3 February 2022

**InterContinental Hotel Concept Development Application (Stage 1 – SSD 7693) - Insertion of Stage 1A Modification to Transport House to facilitate a temporary function centre (SSD 7693 Mod-2).**

View Analysis

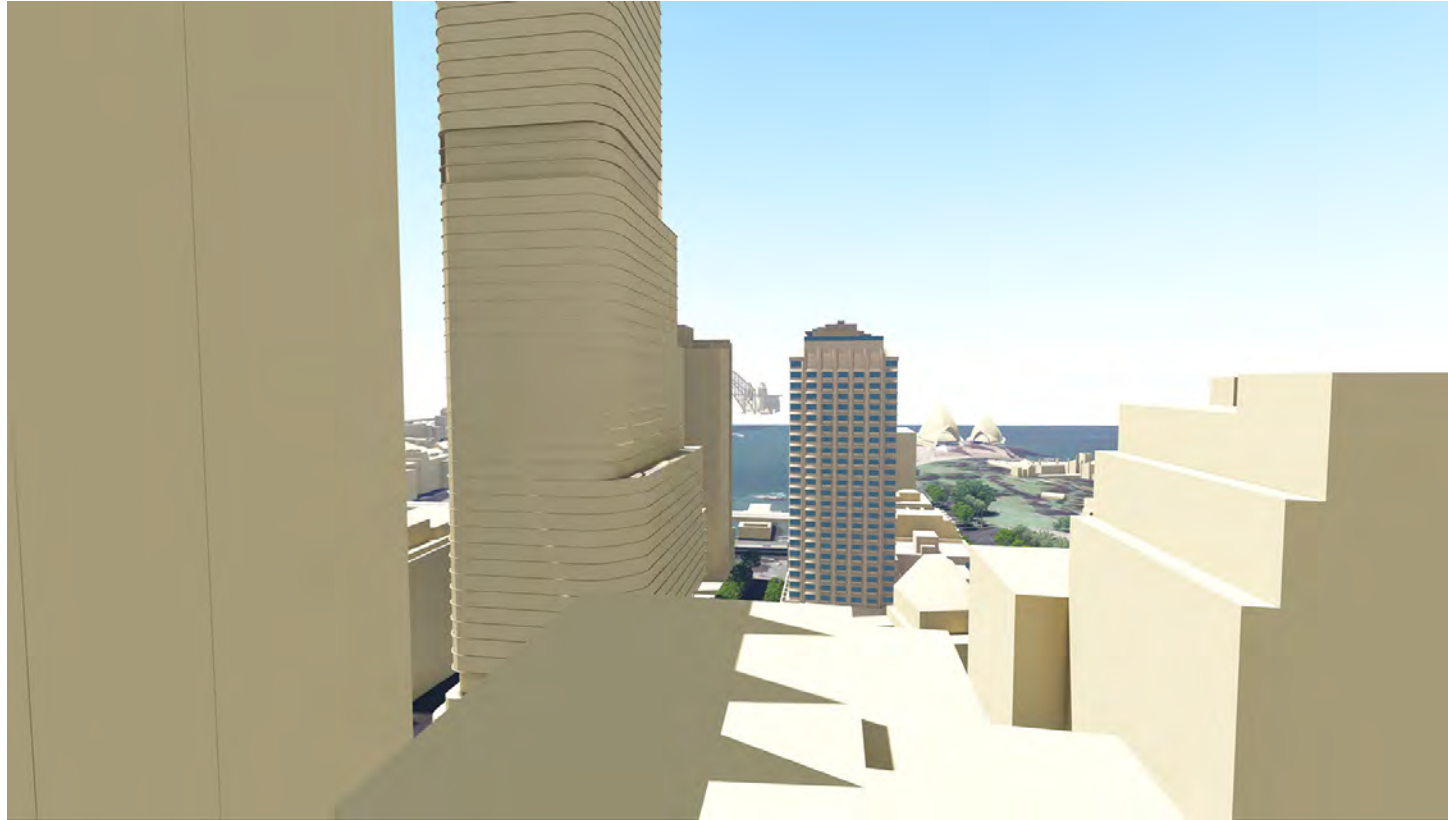
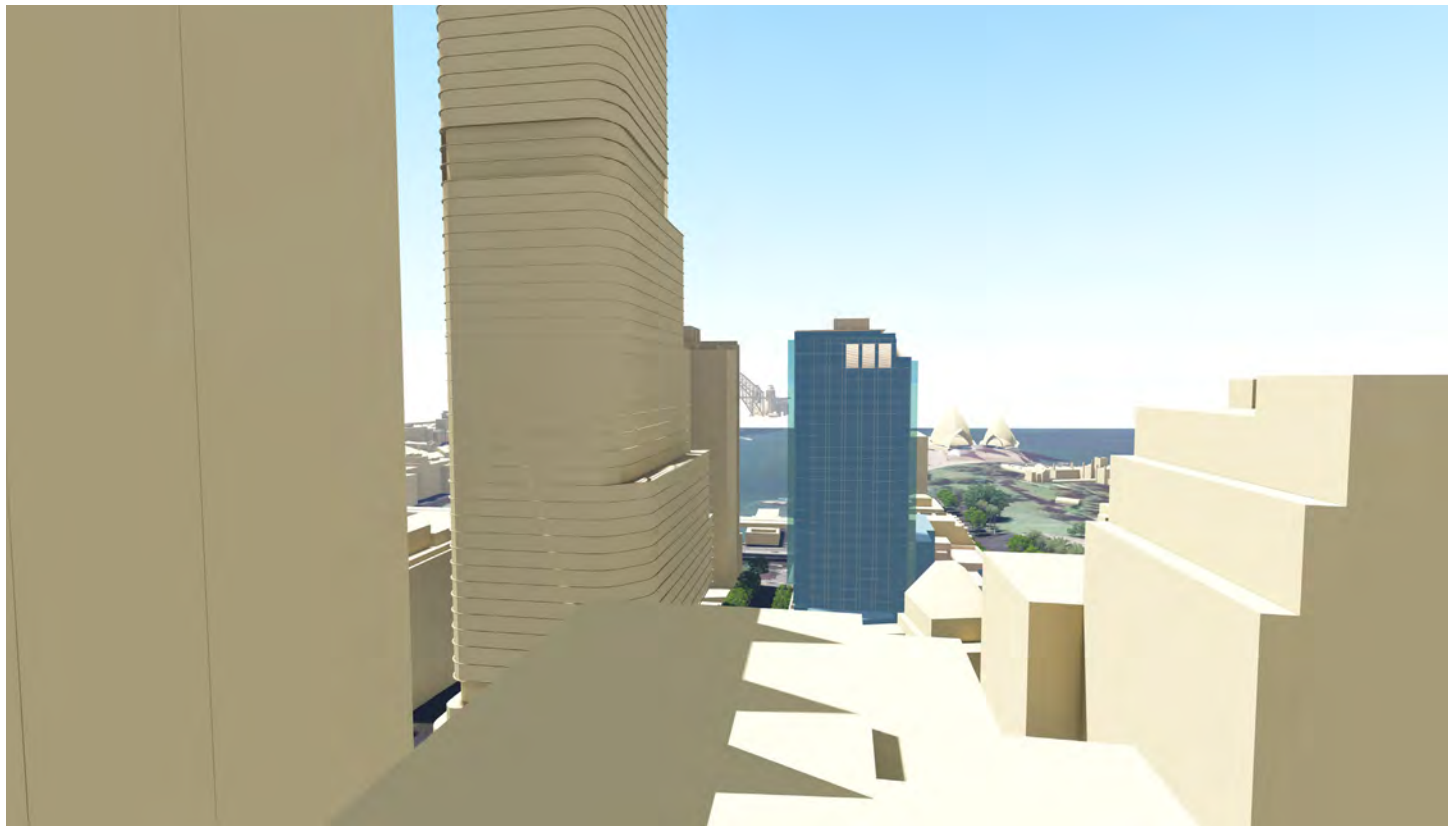
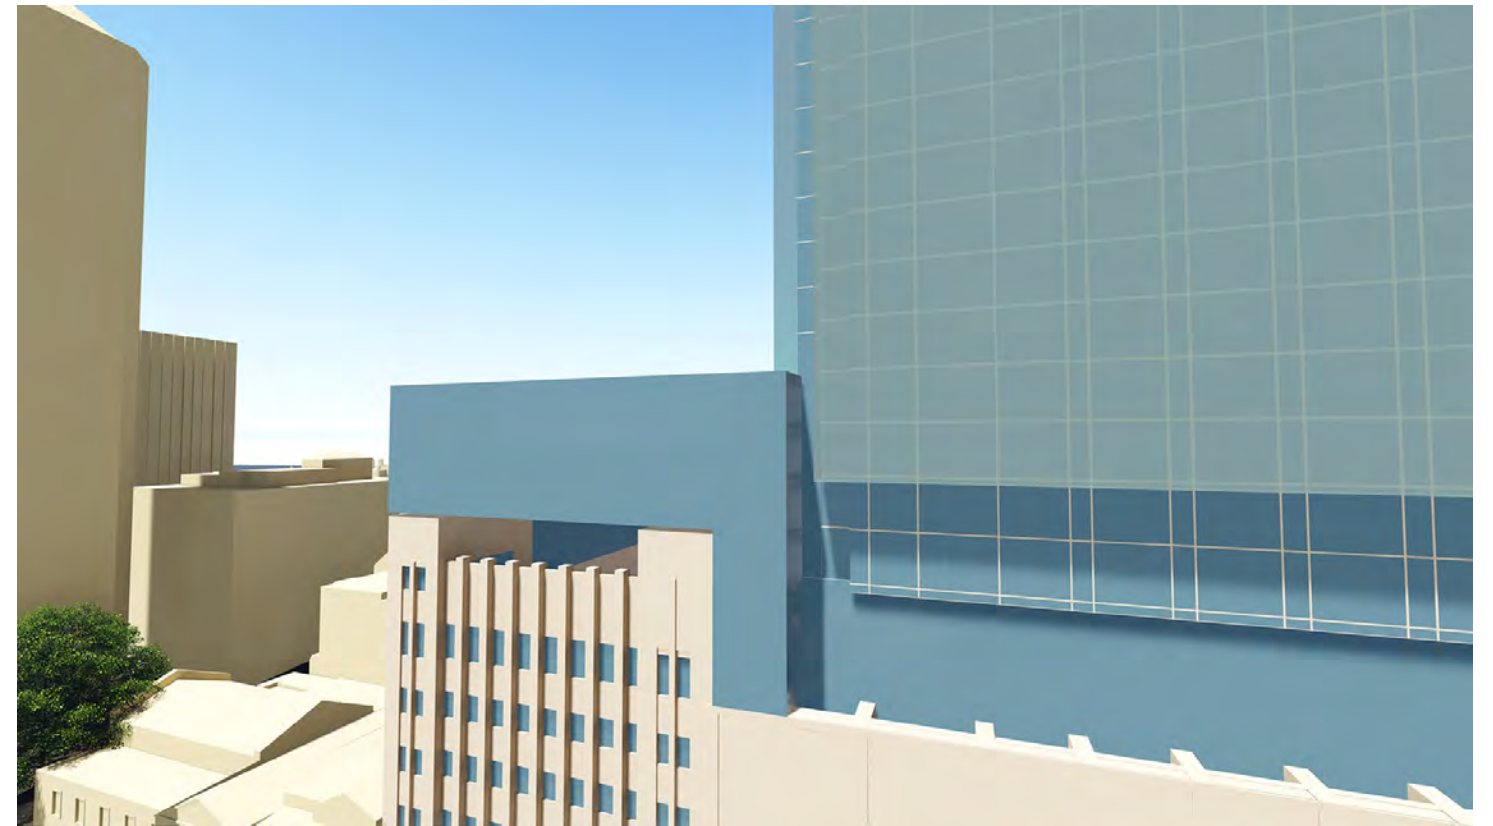
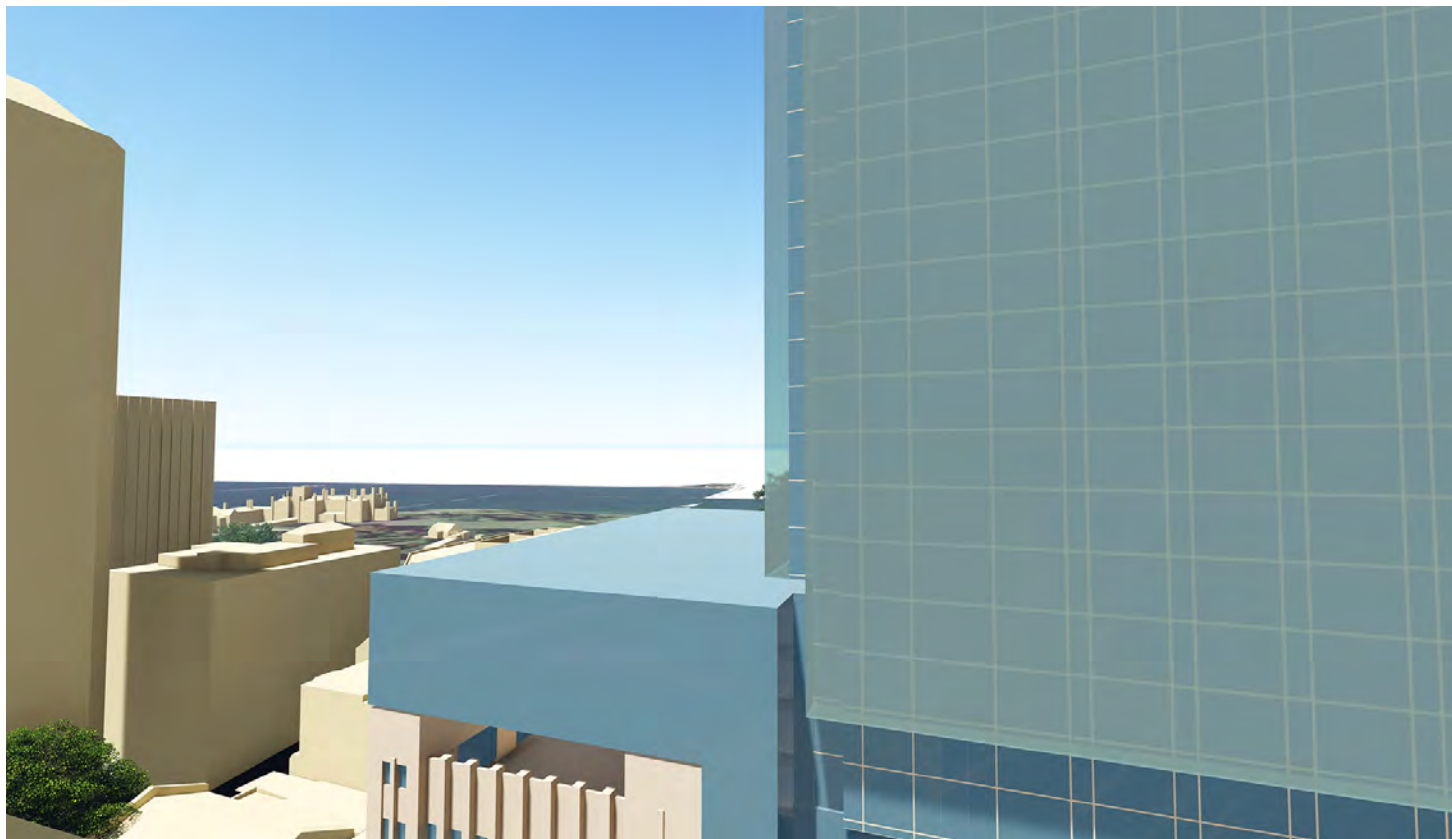
In relation to visual impact, we acknowledged the impact of the proposed development concept is of a temporary nature and not visually dominant against the existing city skyline. However, it would be visible from large areas of the Garden. The building envelope in the application suggests the form and scale of the temporary structure will have a reduced profile and be less intrusive given that it will be constructed off-site using prefabricated material. Nevertheless, the detailed design of the addition is equally important to ensure the successful visual integration with the existing built form in this locality.

We request therefore that any approval for the application should be conditioned to require the detailed design to have a high standard of architectural quality that is sympathetic to their visual and spatial context.
